Your Ref: 2025/91184

Our Ref: A/01971

29th August 2025

Land Off Bretton Street, Savile Town, Dewsbury - (KIRK) Erection of two storey industrial unit (Use Class E(g)(iii)), with associated car park, service area and other associated works

| DRAWING No. | KS826 / D01 | | | REV. | P1 |

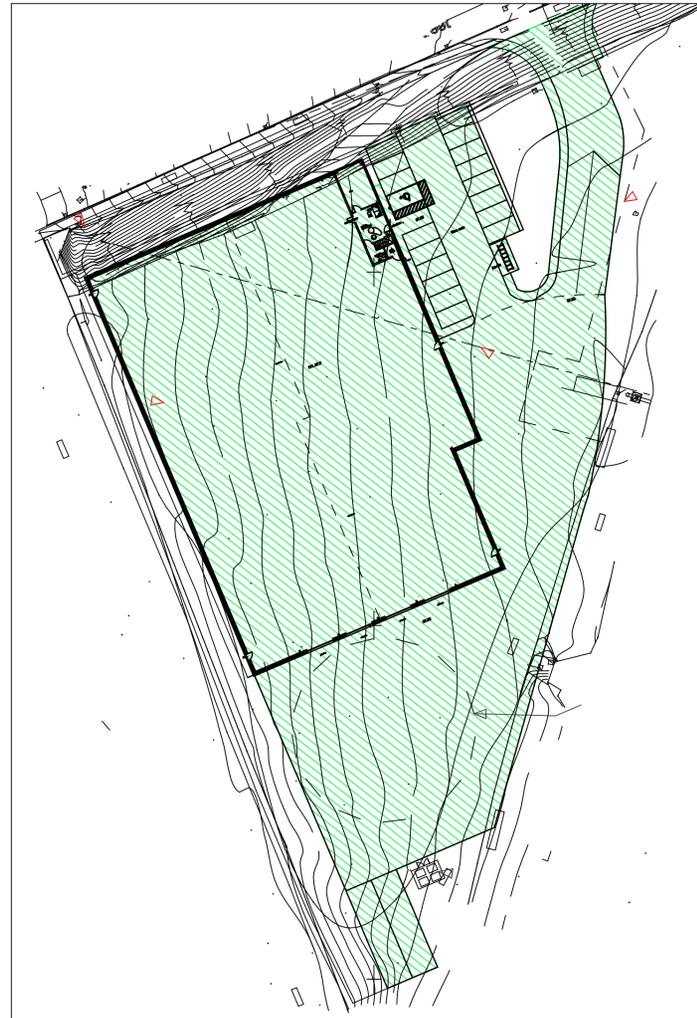
1) Yorkshire Water has no objection in principle to:

- a) The proposed separate systems of drainage on site and off site
- b) The proposed amount of curtilage surface water to be discharged to the public surface water sewer at a restricted rate of 2.5 (two point five) litres/second
- c) The proposed point of discharge of surface water to the public 600mm diameter surface water sewer crossing site
- d) The proposed use of the petrol/oil/grit separator

e) It is noted that foul water will be treated by a private package treatment plant before outfalling to watercourse

submitted on drawing KS826/D01 (revision P1) dated 28/03/2025 that has been prepared by Krypton Structures.

2) On the Statutory Sewer Map, there is a 600 mm diameter public surface water sewer recorded to cross the site. It is essential that the presence of this infrastructure is taken into account in the design of the scheme.

a) It may not be acceptable to raise or lower ground levels over the sewer and we will not accept any inspection chambers on the sewer to be built over.

b) In this instance, a stand-off distance of 5 (five) metres is required at each side of the sewer centre-line and it may not be acceptable to raise or lower ground levels over the sewer, nor to restrict access to the manholes on the sewer.
